Site 68 - Design Review Panel – Out of Session Comments from the Panel

As agreed at the last DRP meeting, the developer submitted the refined façade treatment to the panel, for comment. The key comments received from the panel are as follows:

7.5 TYPICAL FACADE DETAIL

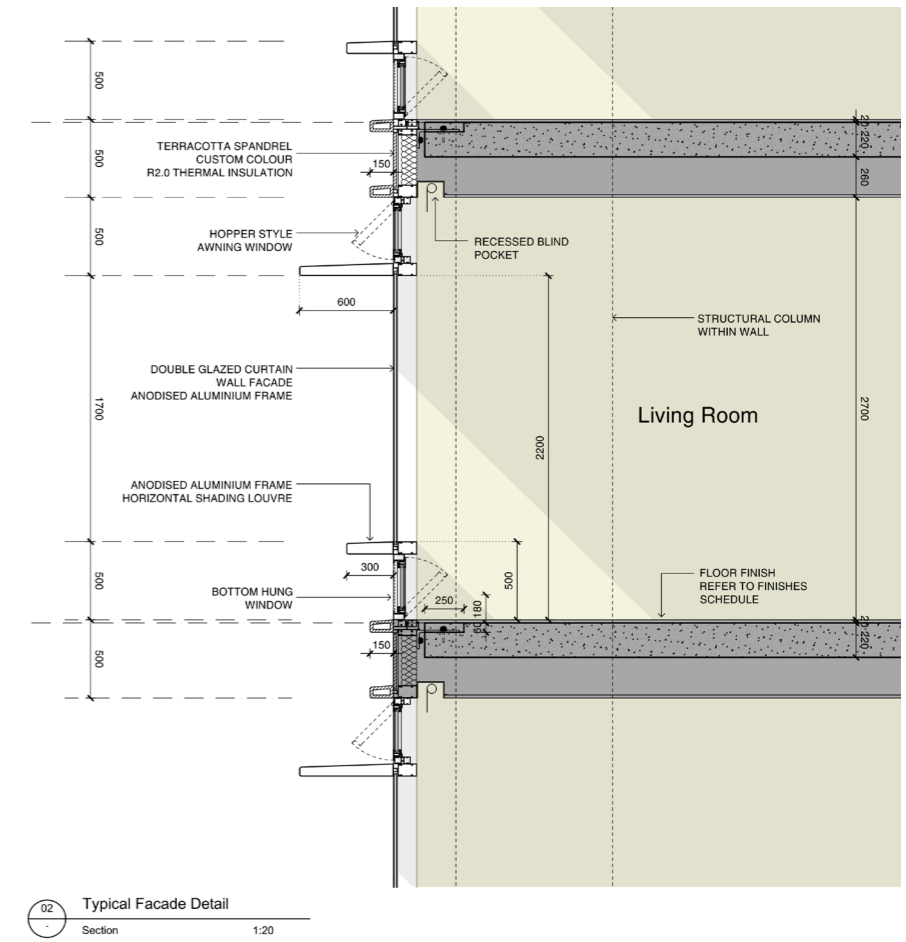
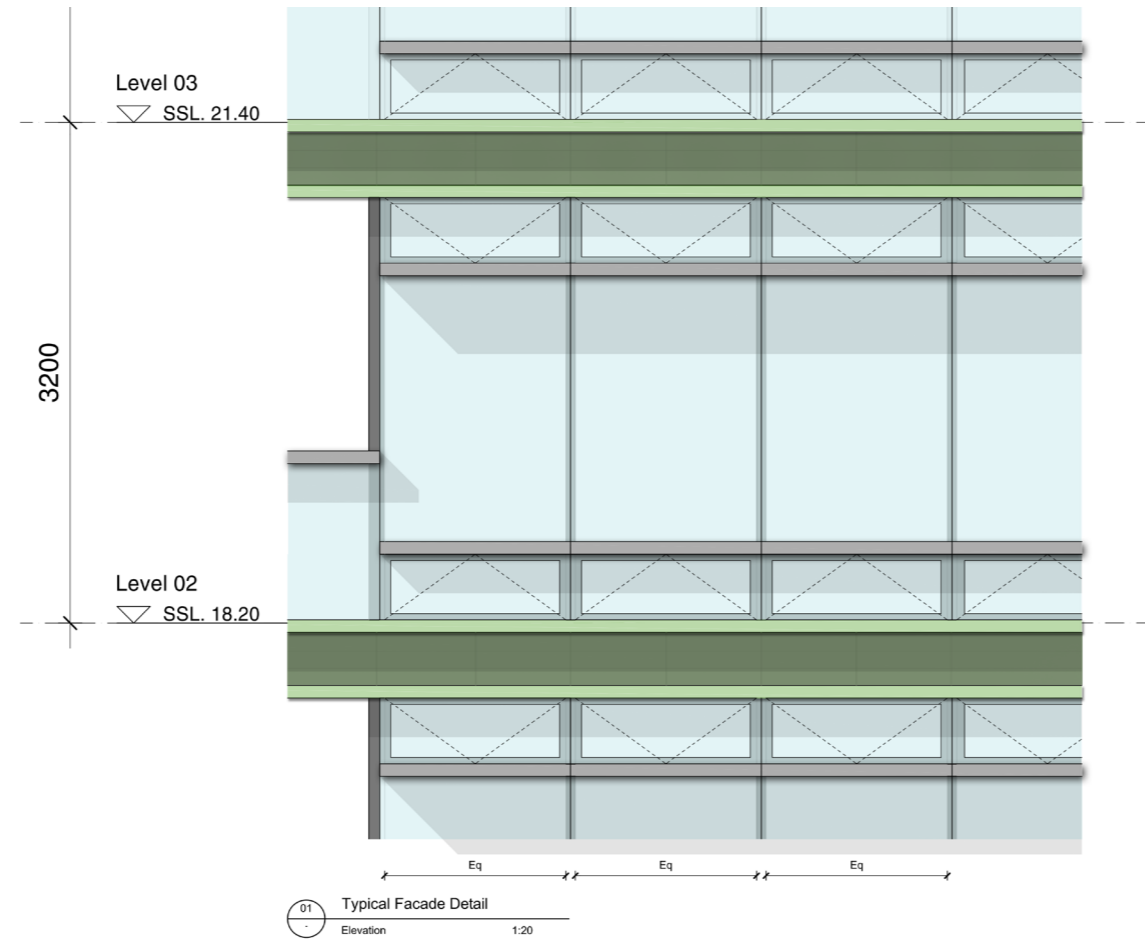
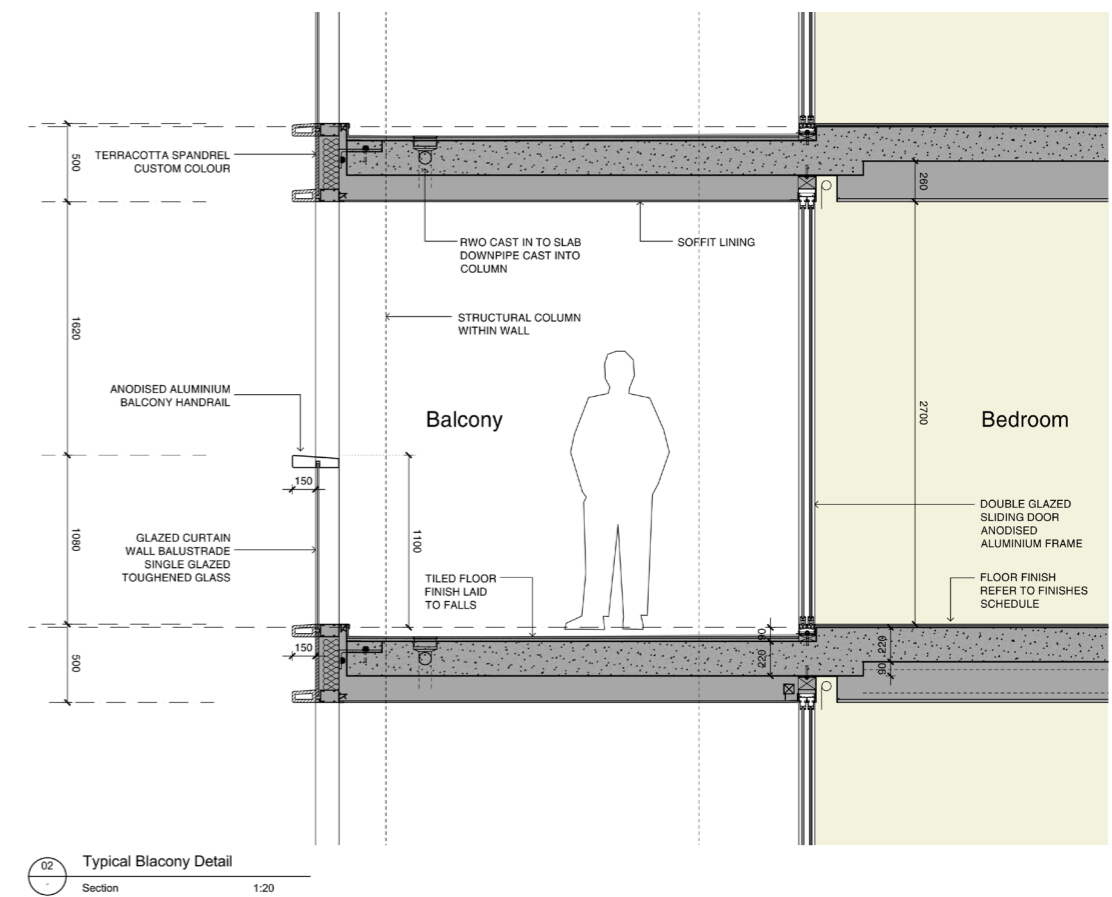
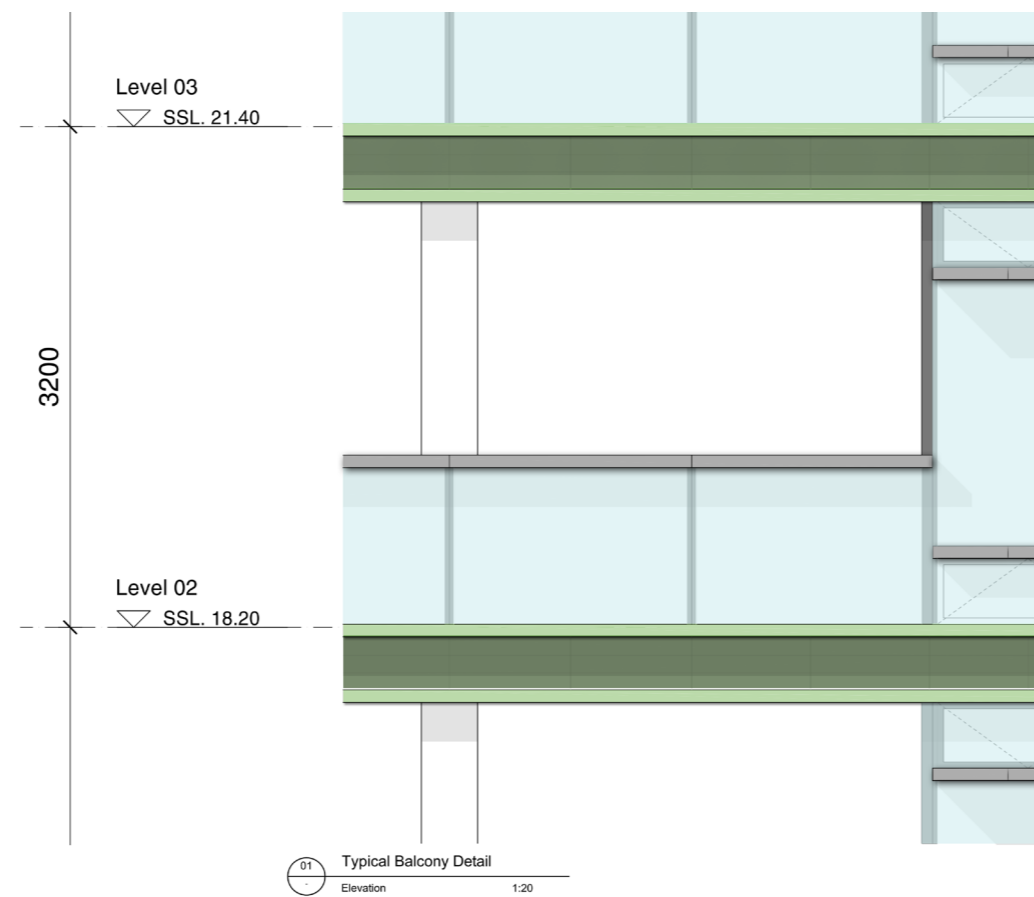
We recommended that there should be more of the terracotta in the facade, with no metal horizontal metal pieces, other than the window and door frames. I think this has been muted down to be too monochrome.

My recollection of our conversation and response was to shift away from the elemental allocation of the terra cotta (to get away from the 'office building' aesthetic) and encourage them to develop their solution, that used more terra cotta rather than the one which had painted aluminium. The discussion went something along the lines, that the painted aluminium is too restrained, 'cool' and structured and that if you didn't have enough terra cotta it trivialised its use and lessened its impact. The attached advice sheet confirms this.

The Panel did not feel it was their place to resolve the colour pallet for the façade. It was however noted that the addition of the aluminum was not ideal and provided a loss of materiality. Similarly the elementary approach to the use of colour did not seem appropriate. The Panel suggested the façade should be subtle as residential buildings should not be iconic in this precinct, but an element of playfulness should also be provided to ensure it does not have a 'commercial' appearance.

The Panel did not feel it was their place to resolve the colour pallet for the façade. It was however noted that the addition of the aluminum was not supported. Similarly the elementary approach to the use of colour did not seem appropriate. The Panel suggested the façade should be subtle but an element of playfulness should also be provided to ensure it does not have a 'commercial' appearance.
